Application for a non-material amendment following a grant of planning permission. Town and Country Planning Act 1990

Single storey rear extension, first floor side extension & 2 No. roof lights within loft space

Reference number: R/101/15/HH

6. Non-Material Amendment(s) Sought

Proposed Main Elevations [proposed building work highlighted in yellow]

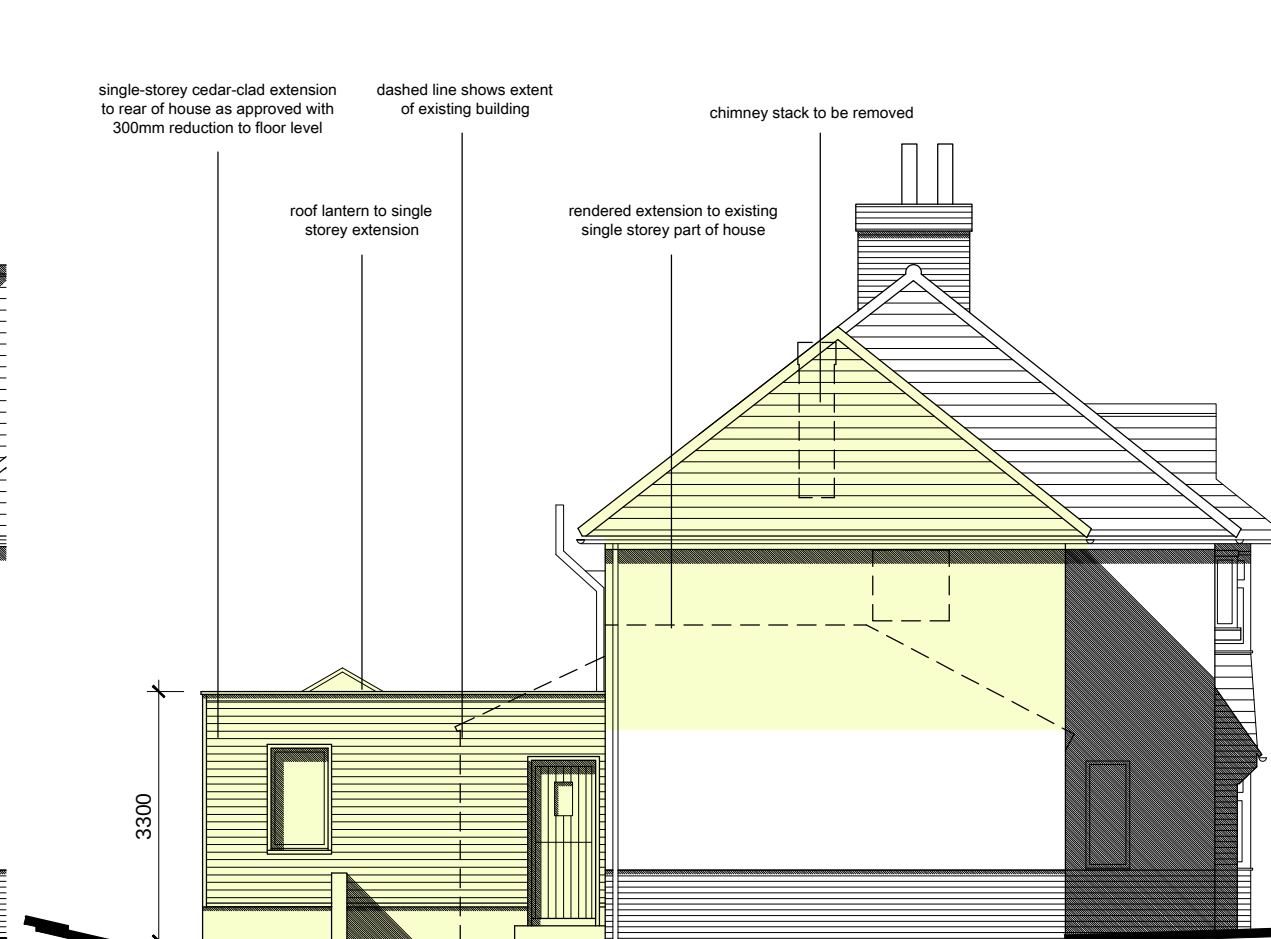
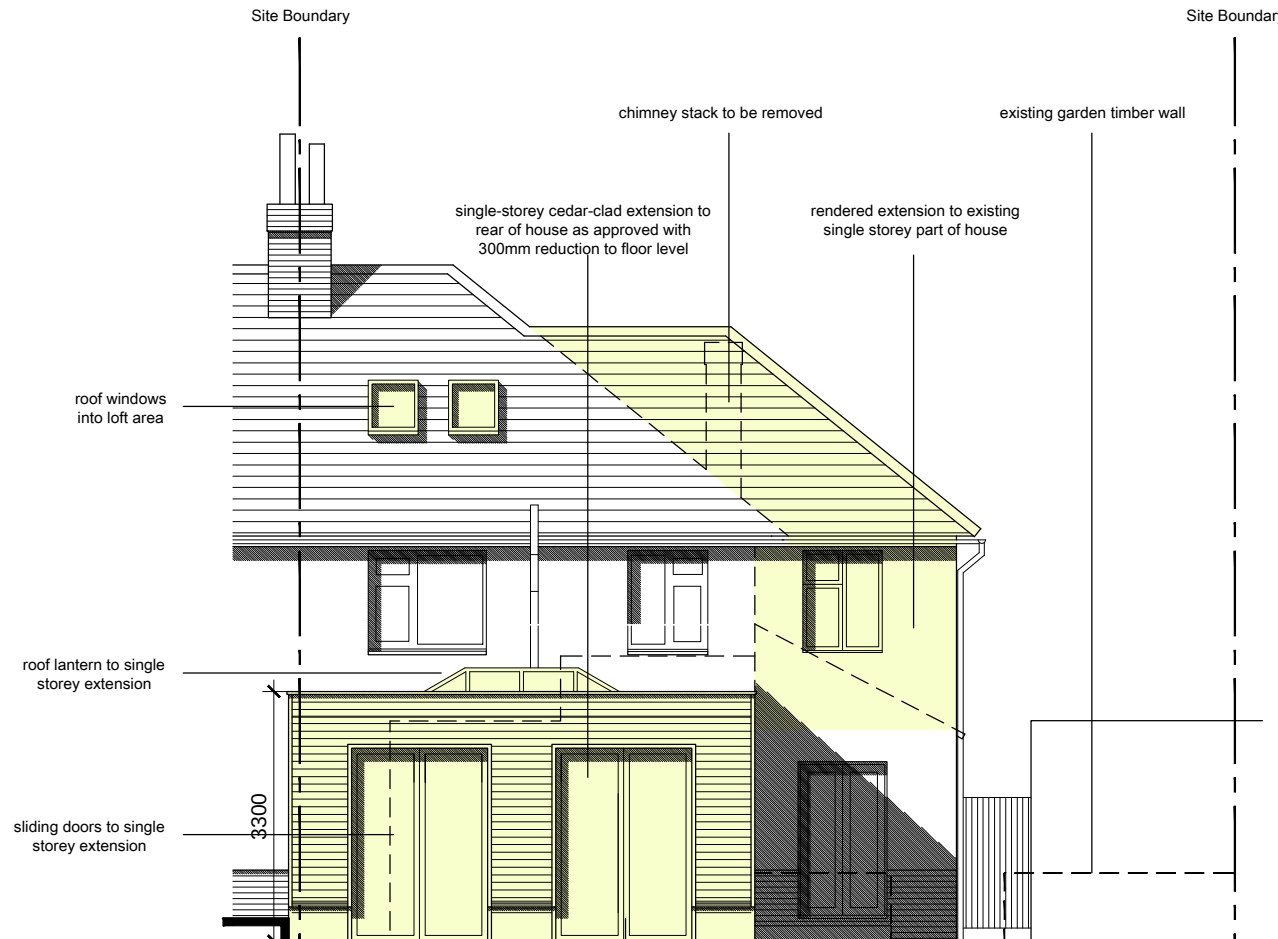
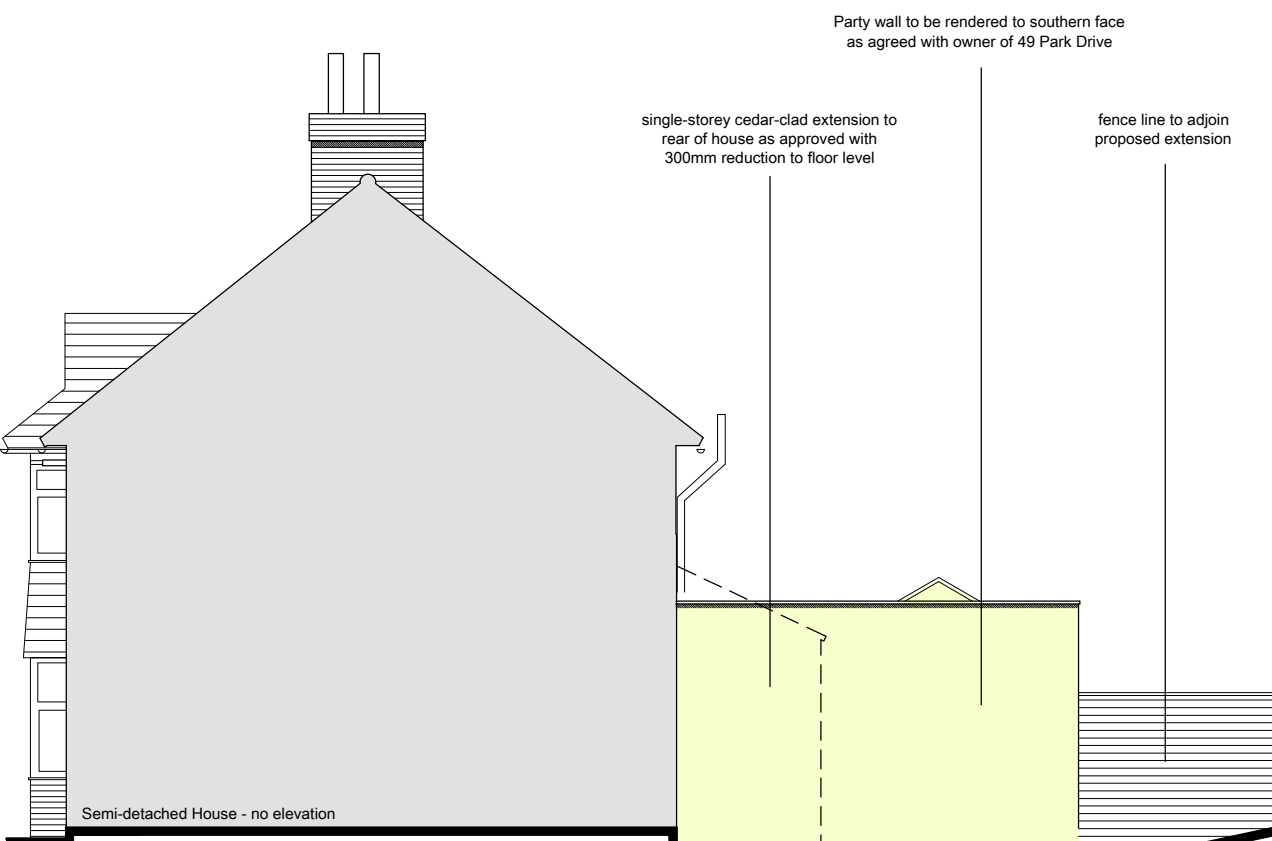
Reduction in floor level of rear extension by 300mm, with parapet height remaining as approved.
As there is no increase in height to the extension, there are no effects to any surrounding property and therefore no reason for the proposed amendment to be resisted.

Indicative Section thru Extensions Scale 1:100 @ A1

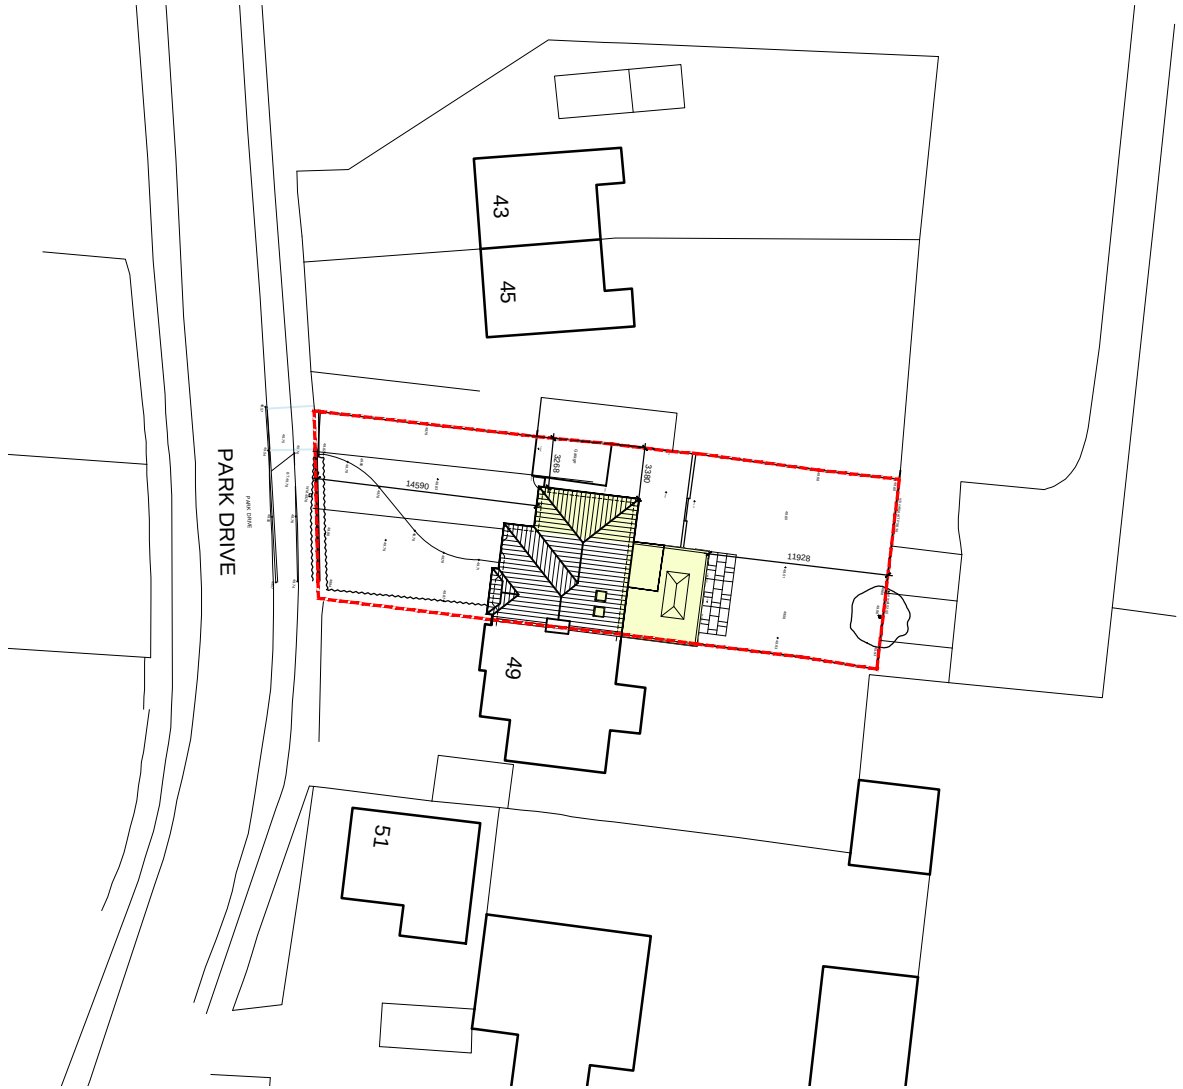
To reduce the floor level in the proposed extension. This amendment will not be visible by anyone except the property owner.
